MOUNT OWEN CONTINUED OPERATIONS PROJECT

Clarification of Project and Assessment
Findings Report

**Re: Mount Owen Continued Operations Project – EIS Figure amendment clarification –
Figure 2.15 Hebden Road Upgrade Works**

Hebden Road Upgrade Works
 Conceptual Design

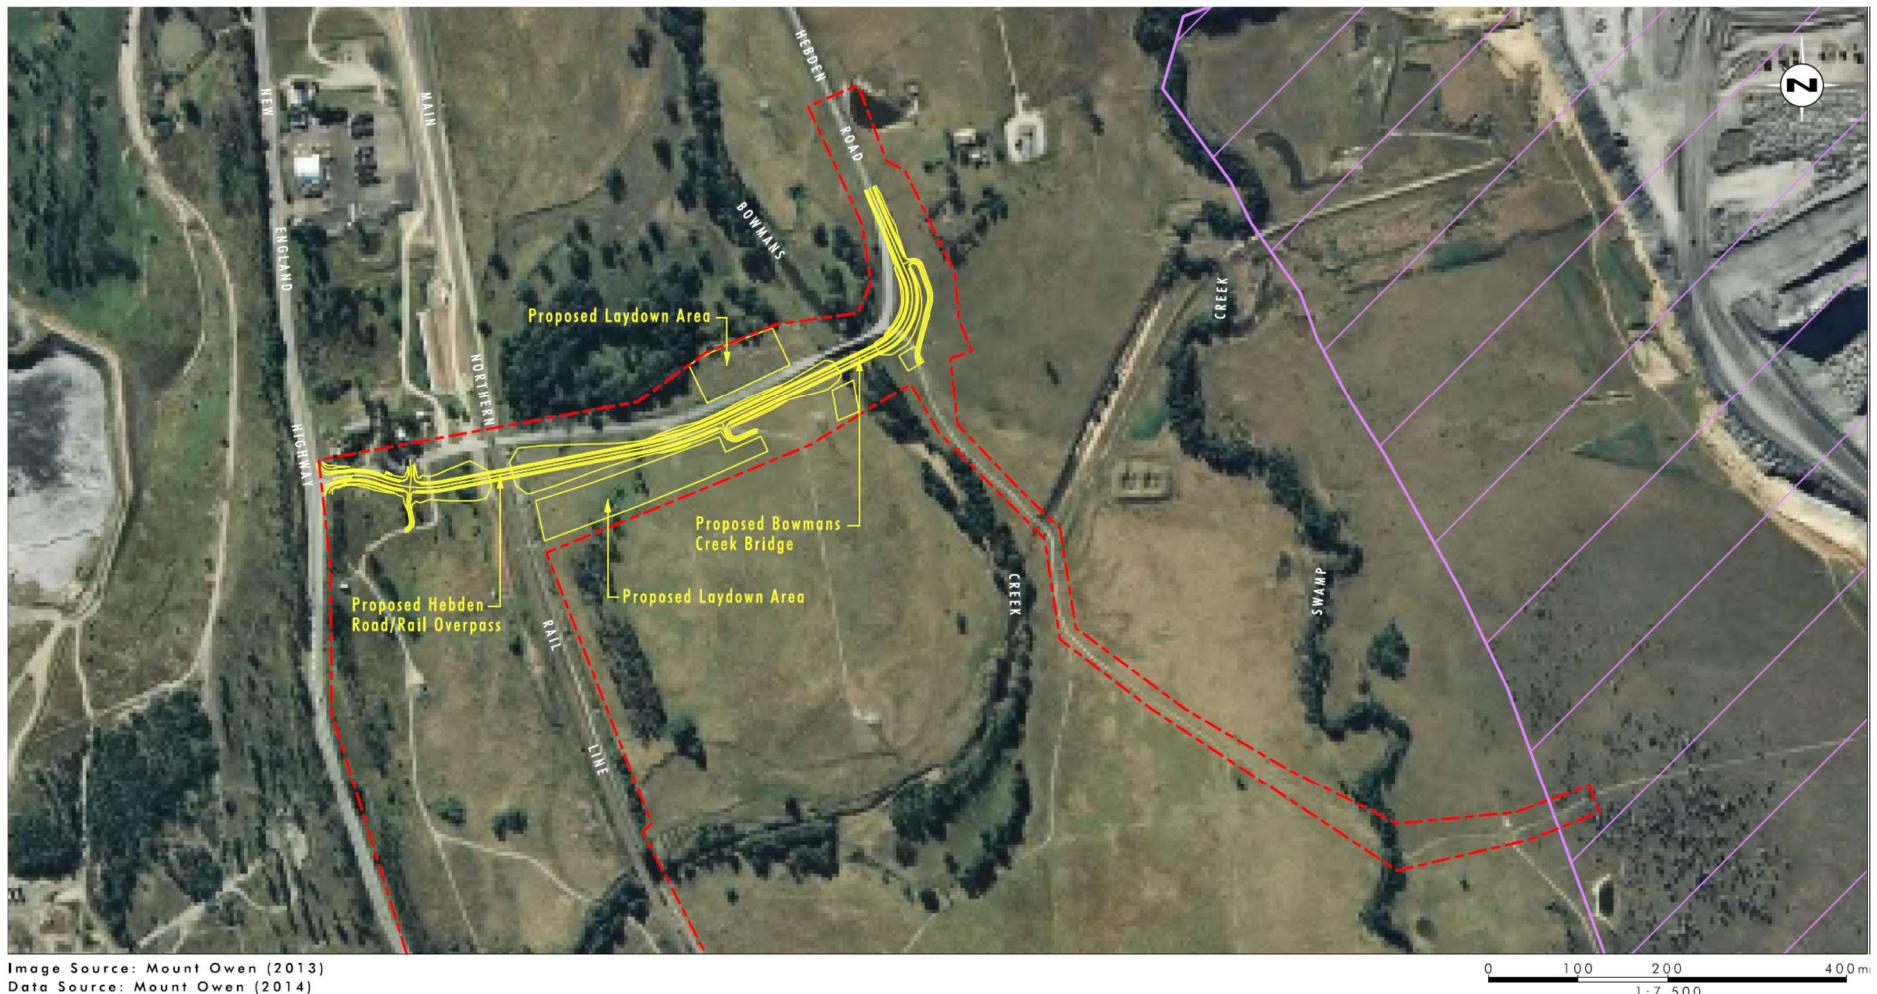
Following review of the draft conditions for the Mount Owen Continued Operations Project it has come to our attention that there has been some confusion in regard to the proposed Hebden Road Upgrade Works, and specifically we wish to clarify that there are no works proposed at the existing Hebden Road/New England Highway intersection. On reviewing this matter, we now understand that this confusion has arisen from an error on Figure 2.15 (Hebden Road Upgrade Works), provided with the EIS. We note that the text of the EIS, the supporting Traffic Impact Assessment (TIA) and Response to Submissions report all state that upgrade works to the Hebden Road / New England Highway intersection are not required for the Project. The relevant detail on this matter is provided below.

The details provided in Figure 2.15 of the EIS erroneously included the relevant figure layers for the previous design option in addition to the currently proposed works and does not accurately reflect Project related works in this area. Accordingly, this figure has been revised and is attached. It is requested that the DPE assessment report refer to the attached corrected figure and this be reflected in relevant conditions of consent for the Project.

Accordingly, the proposed design was revised to remove all works to the existing intersection, apart from the works associated with the approach to the intersection on Hebden Road, associated with the proposed works described above.
